Response to Additional Submissions | STACK SYD01 Data Centre, Erskine Park (SSD-82211208)

This letter has been prepared by Urbis Ltd on behalf of STACK Infrastructure in response to additional comments received in relation to the proposed STACK SYD01 Data Centre at 78 Lockwood Road, Erskine Park (SSD-82211208) and the associated Amendment package.

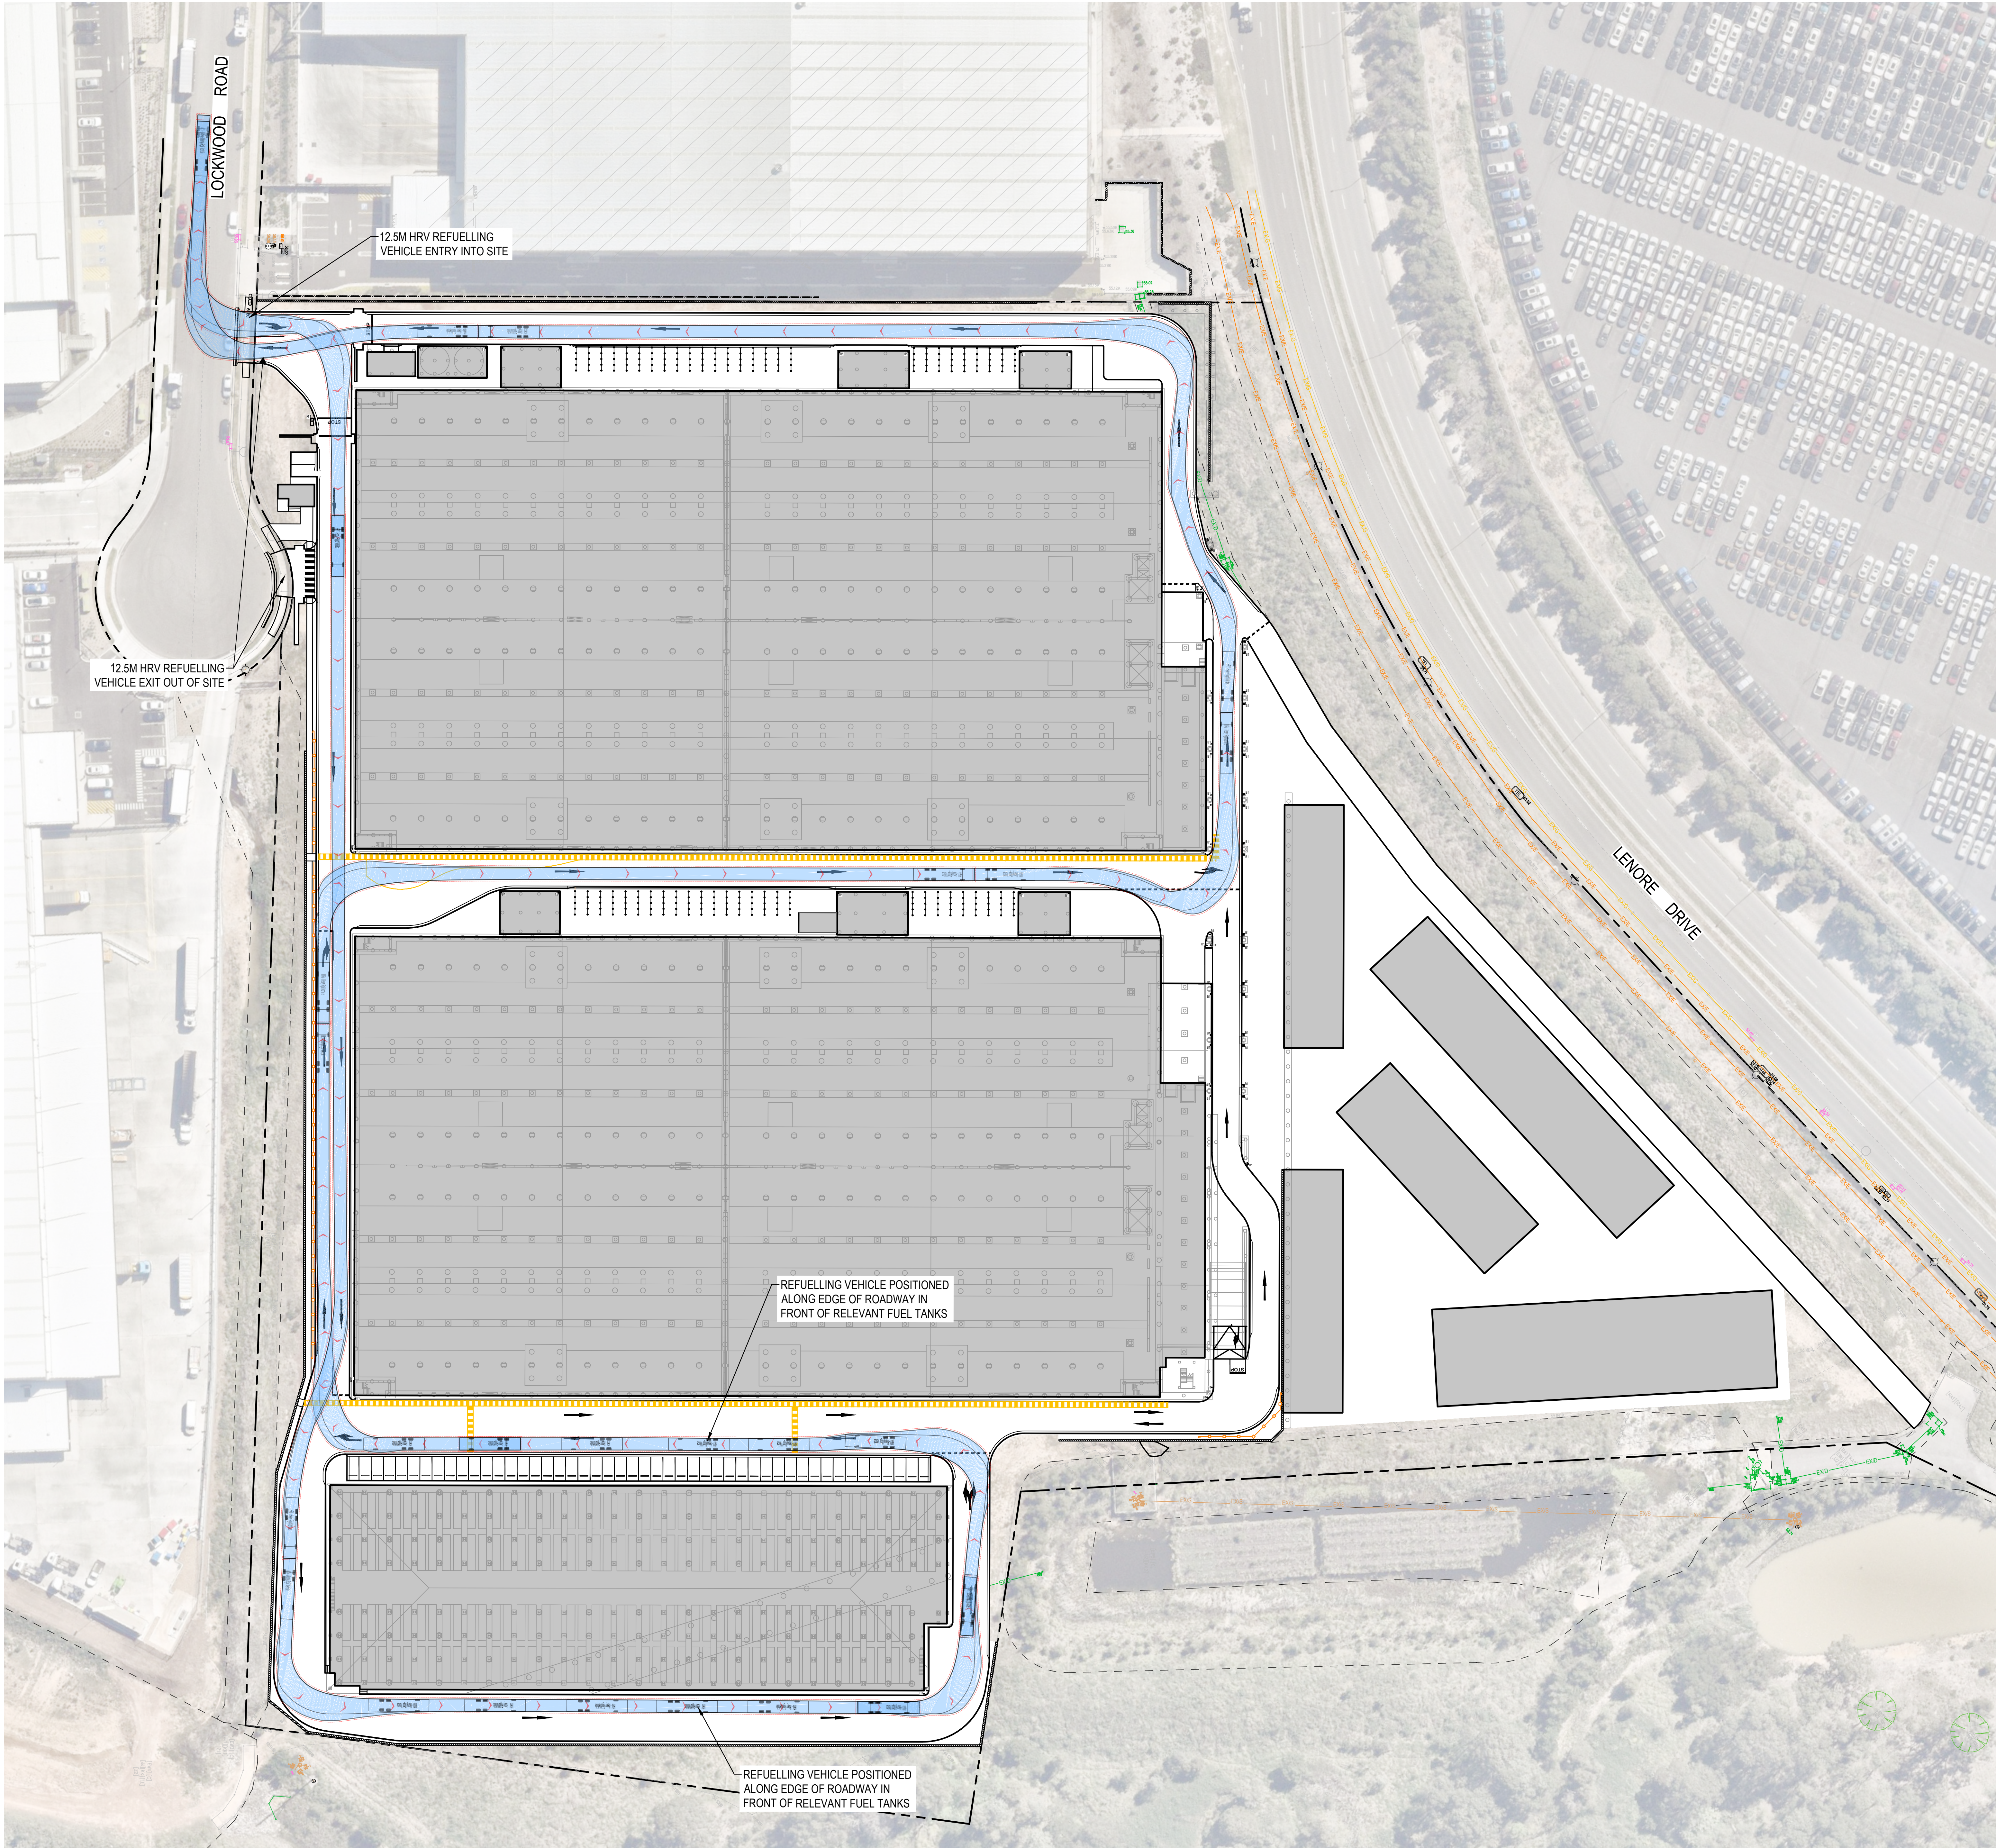
a) The storage of diesel and the re-fuelling of diesel tanks need to be considered at this stage. A pollution management plan should accompany the application detailing strategies to prevent spills and, should spills occur, methods to protect the stormwater system and other sensitive areas.	The management of diesel storage, refuelling and spill containment has been comprehensively addressed within the supporting technical documentation submitted with the application. In particular, Section 7.4 of the Dangerous Goods Compliance Report outlines the spill containment and fuel handling requirements necessary to achieve compliance with AS 1940, including measures relating to fuel storage, refuelling operations and spill management. In addition, the proposed stormwater management system incorporates two Gross Pollutant Traps that treat all piped stormwater runoff prior to discharge to the constructed wetland. The nominated GPT units include hydrocarbon baffles specifically designed to capture and retain free hydrocarbons, thereby providing an additional level of protection in the unlikely event of a fuel spill. Further details of the proposed stormwater quality treatment measures are provided in Section 5.4 of the Integrated Water Management Plan (IWMP). Collectively, the Dangerous Goods Compliance Report and IWMP demonstrate that appropriate measures have been incorporated into

TREE CANOPY COVER

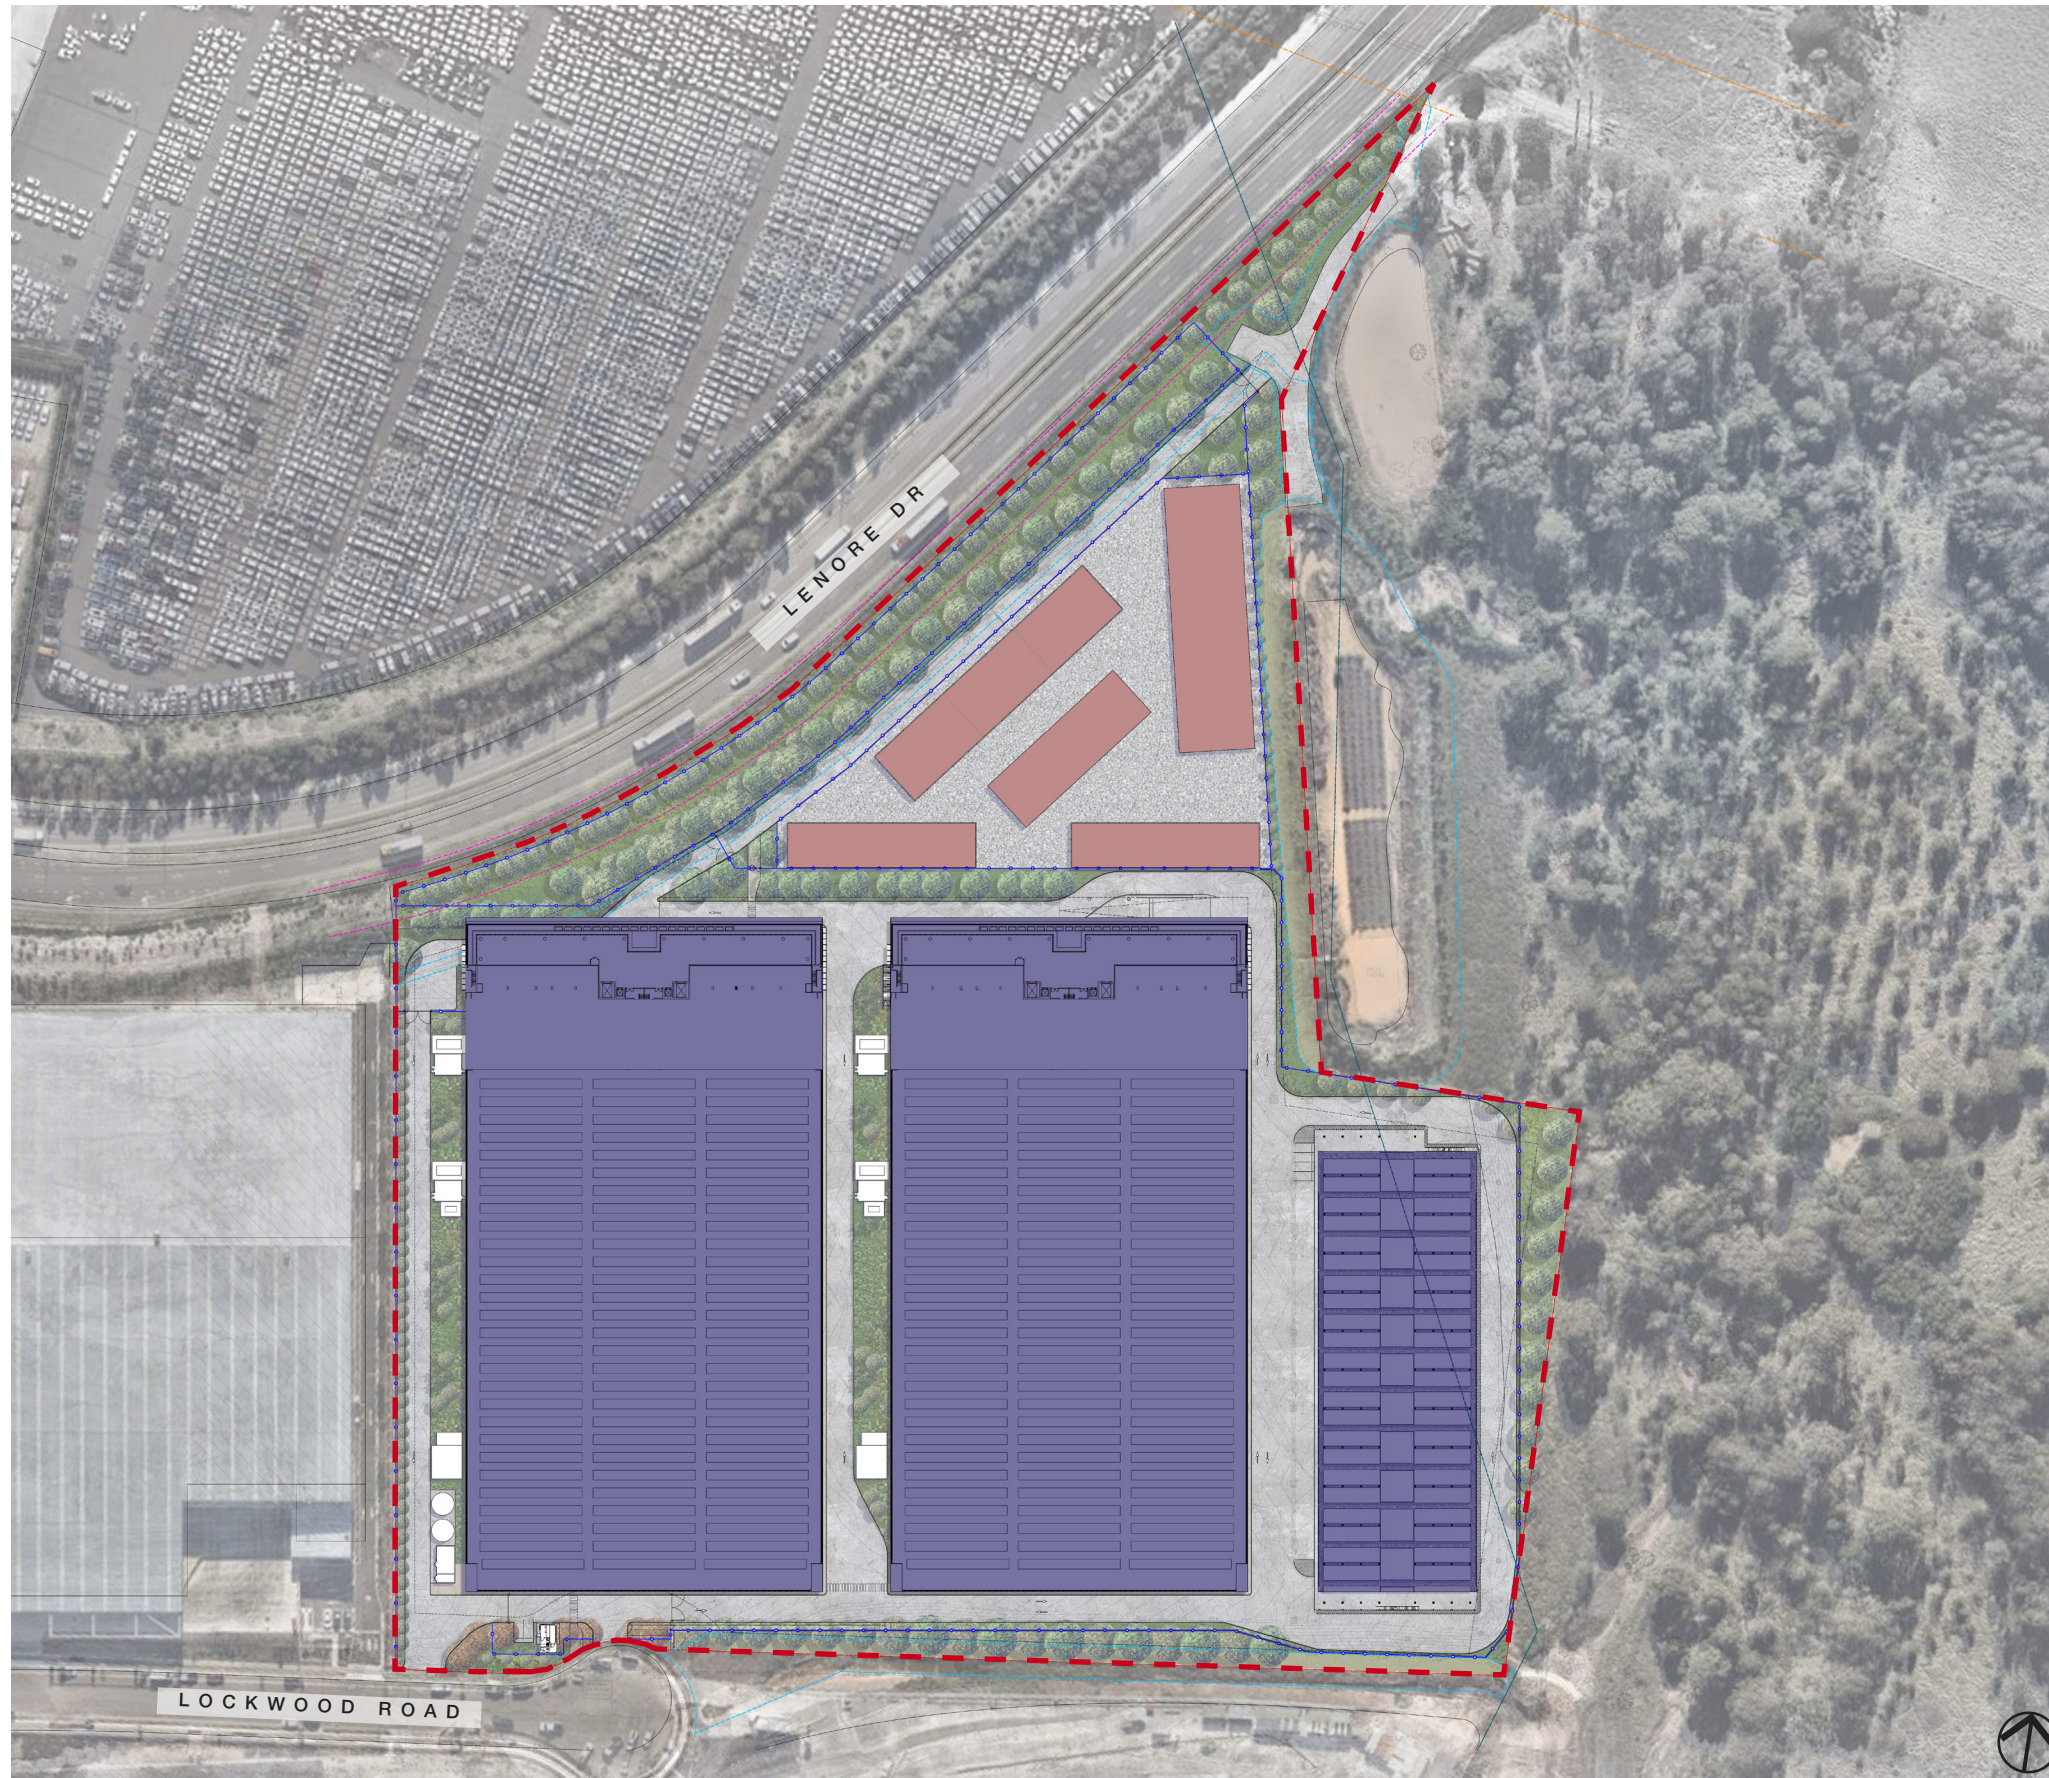
r) The proposed reduction in tree canopy coverage is not supported and does not address the objectives and controls related to Urban Heat which are at Chapter C14 of the Penrith DCP.	The proposed landscape design has been developed to maximise tree planting opportunities across the site while balancing a range of operational, servicing and safety constraints associated with the development. The landscape strategy has been carefully designed to provide meaningful canopy planting, urban greening and urban heat mitigation outcomes. The proposed canopy tree planting has been maximised within available landscape areas having regard to a number of site-specific constraints, including: ▪ Underground infrastructure corridors including gas, water, sewer, power and optic fibre services. ▪ Existing and proposed electrical easements and associated restrictions. ▪ The operational requirements of the data centre development, including setbacks required for buildings, plant, servicing and supporting infrastructure.

Heat Impacts	
a) Western Sydney is prone to periods of extreme heat. The development is anticipated to produce an urban heat island effect during the construction and ongoing use phases. This includes the heat generated through the	An Urban Heat Island Mitigation Diagram has been prepared to illustrate the key design initiatives incorporated into the proposal to reduce potential urban heat island effects. The diagram identifies measures

Comment	Response
operation of the data centre. Heat impacts should be considered as part of the EIS and be accompanied by heat emissions calculations and strategies to minimise heat impact. The cumulative impacts of heat should be considered given the proximity to and heat impacts of the mega data centre nearby.	including deep soil and permeable areas, increased tree canopy cover, reflective roof and façade materials, water sensitive urban design measures, cross ventilation, biodiversity planting and blue-green links. These measures are integrated into the site layout, landscape design and built form response. The proposal incorporates low absorptivity and high solar reflectance external finishes to reduce solar heat absorption and minimise heat radiated back into the surrounding environment. The proposal also includes substantial landscaping and deep soil planting areas which provide shade, support canopy growth and contribute to cooling through evapotranspiration. The integration of WSUD measures further assists in cooling outcomes through increased moisture availability and vegetation establishment. The site adjoins a substantial area of woodland vegetation associated with the Ropes Creek corridor, which provides an established cooling influence and contributes to the moderation of local temperatures. The proposal strengthens connections to this broader green and blue infrastructure network through landscaping, biodiversity planting and ecological connectivity measures. The proposal has also been designed to maximise operational energy efficiency and minimise heat rejection. As outlined in the ESD Report, the facility targets an annualised PUE of less than 1.3 through the implementation of highly efficient cooling and building services systems. In combination, the proposed building materials, landscaping, WSUD measures, adjacent vegetation corridors and operational efficiency measures are considered to appropriately respond to urban heat considerations and minimise the potential for adverse urban heat island impacts, including cumulative impacts within the broader precinct. Refer to the Urban Heat Island Mitigation diagram.
